**KIRKLEES METROPOLITAN COUNCIL
INVESTMENT & REGENERATION SERVICE**

DELEGATED DECISION TO DETERMINE PLANNING APPLICATIONS

Reference No:	2021/62/94599/E
Site Address:	Moorhouse Farm, Moorhouse Lane, Birkenshaw, BD11 2AY
Description:	Demolition of existing buildings and erection of 6 dwellings and associated works
Recommending Officer:	Callum Harrison

Officer Report

# Proposed Site Layout - 1:750

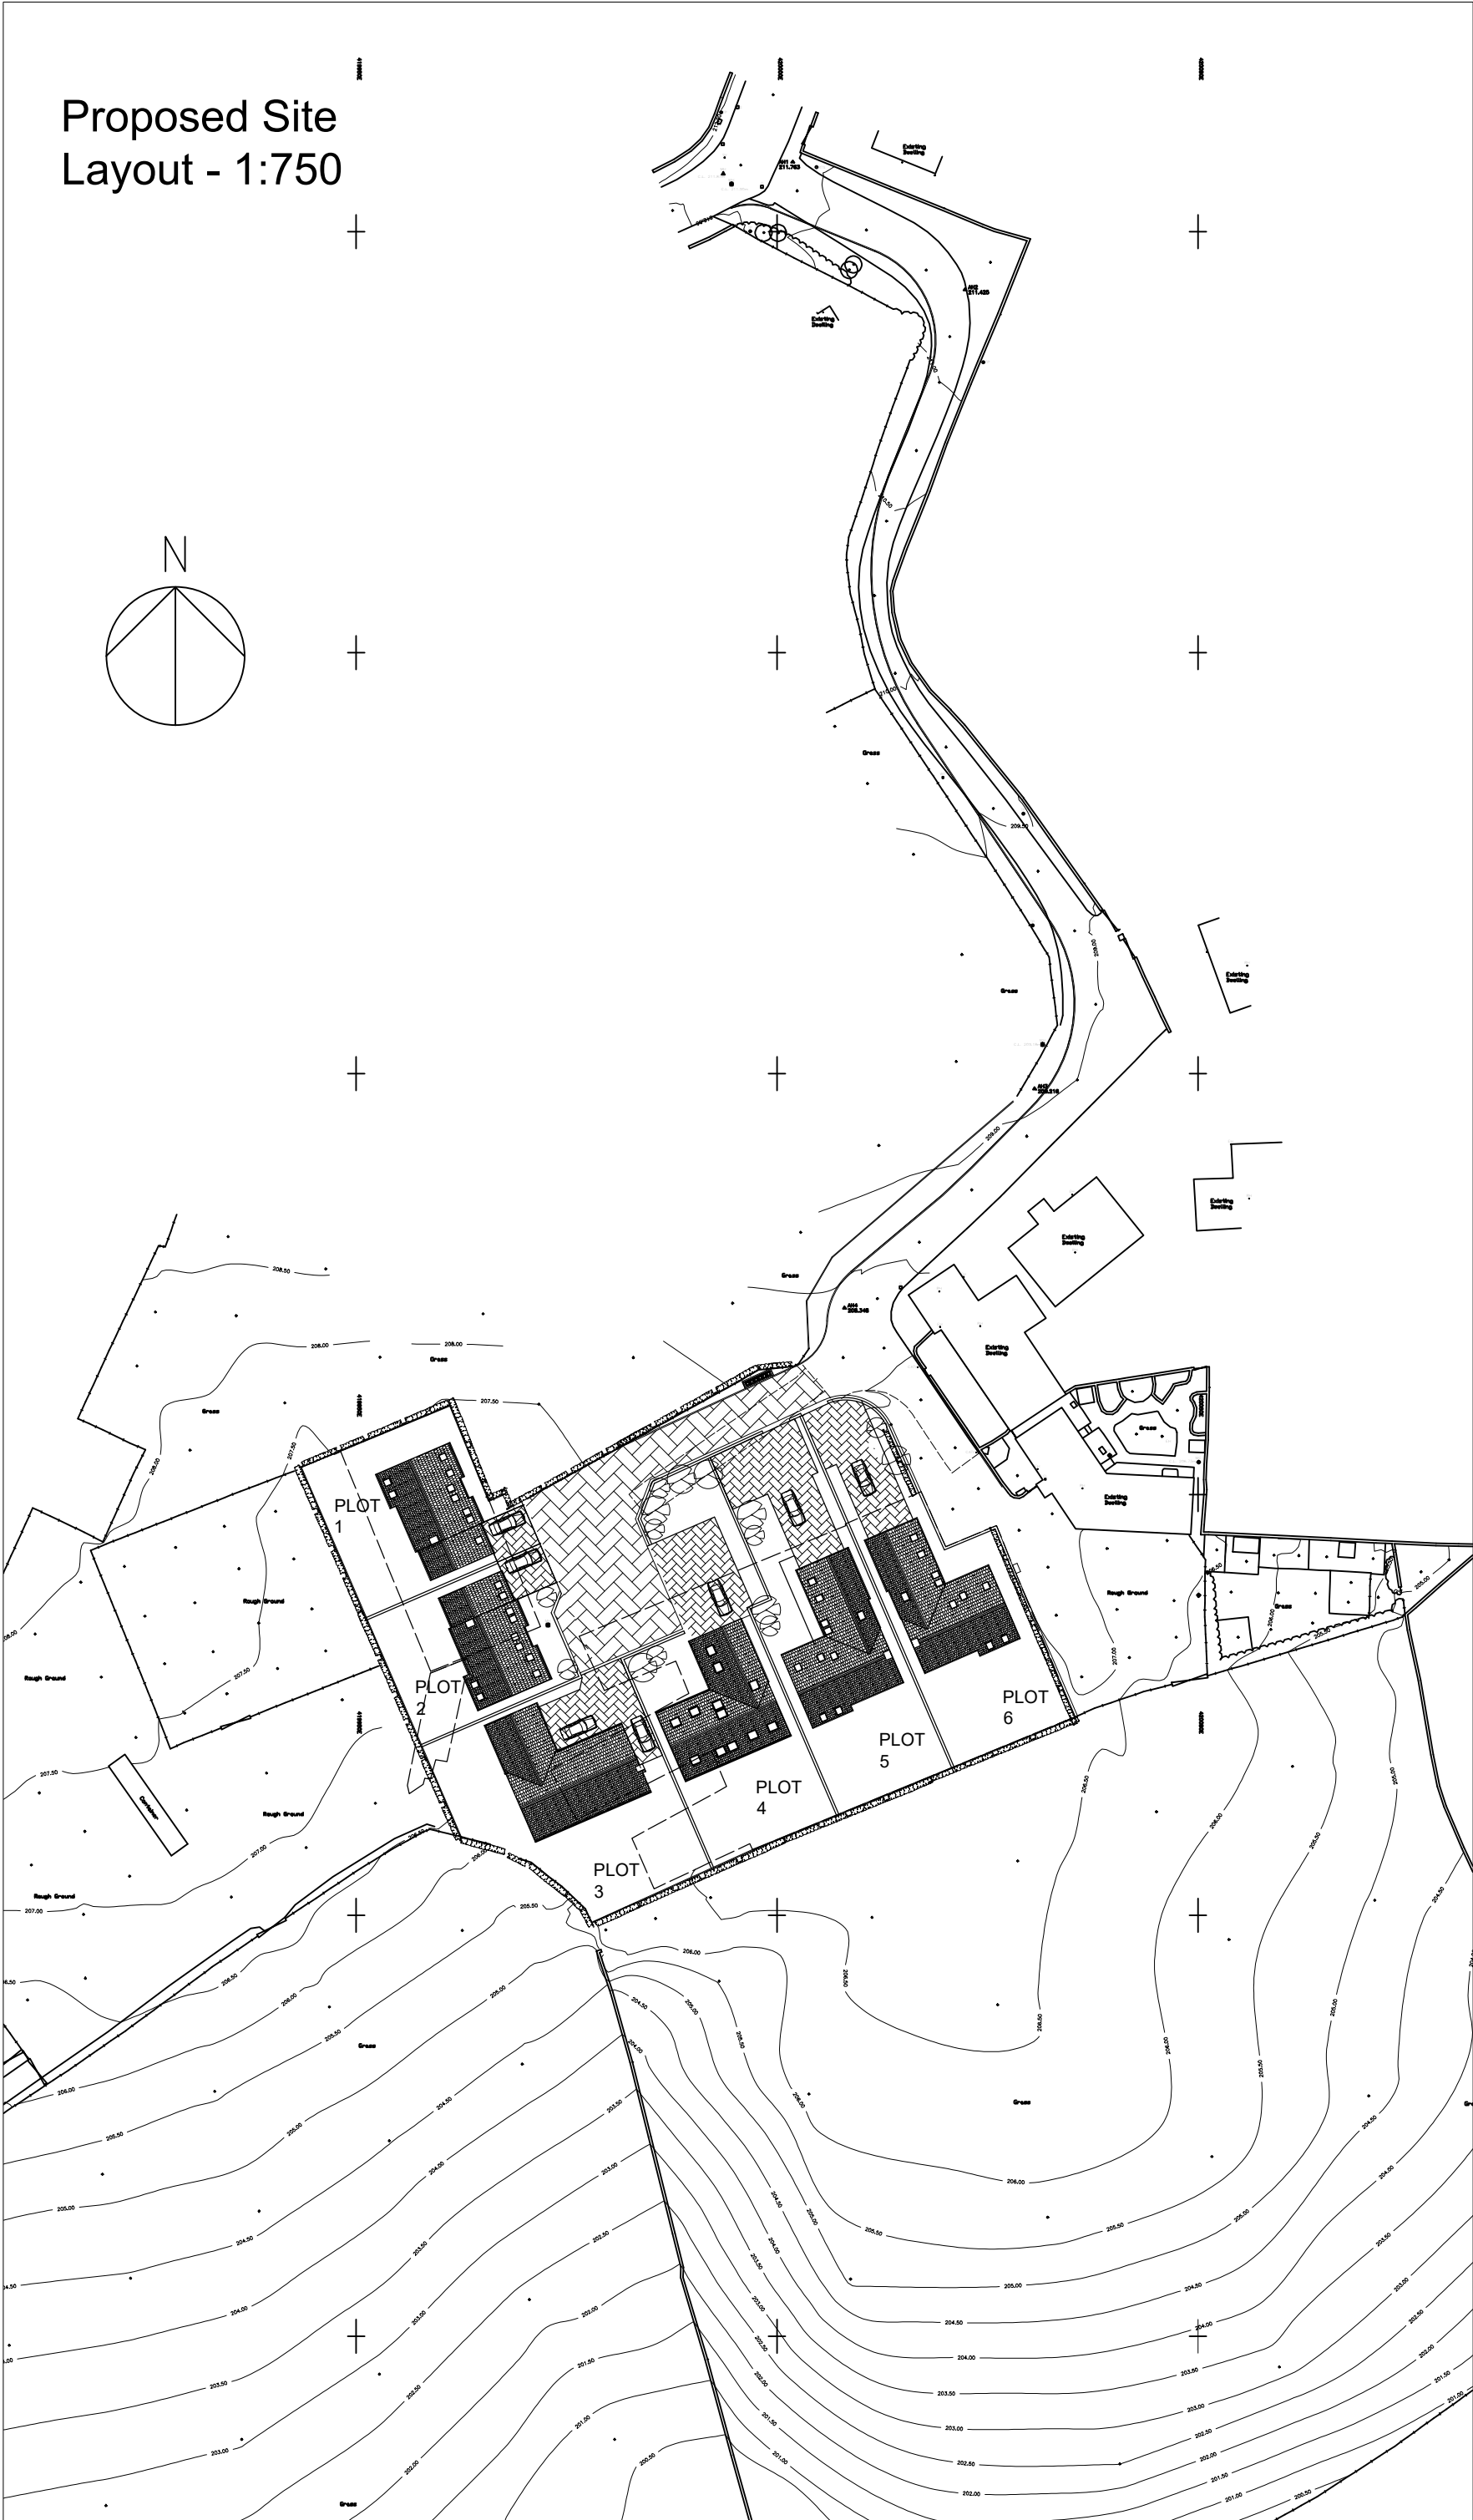
The residential development will be accessed directly off Moorhouse Lane by the way of a dedicated, shared driveway leading to off street parking, garaging, turning facility, shared block paved courtyard and amenity area. The development area will comprise of a six detached dwelling houses, with each unit benefiting from allocated garaging and parking.

The scheme also proposes improvements and alterations are proposed to allow for the widening of the carriageway on Moorhouse Lane to at least 4.8 metres allowing for simultaneous two-way traffic flow along with a 2-metre footway to one side. The driveway improvements will accommodate a Kirklees Council refuse vehicle and allow the vehicle to safely enter and exit the shared driveway arrangement in a forward gear, negating the requirement for any lengthy reversing movements. Furthermore, the proposals will provide internal turning for a large fire appliance within the courtyard area.

- Concerns with regard the location / angle of the access and its impact of the access on to existing dwellings.

Officer Response: Officers agreed with this point and resolved the matter through revising the proposed access to utilise the existing access point.
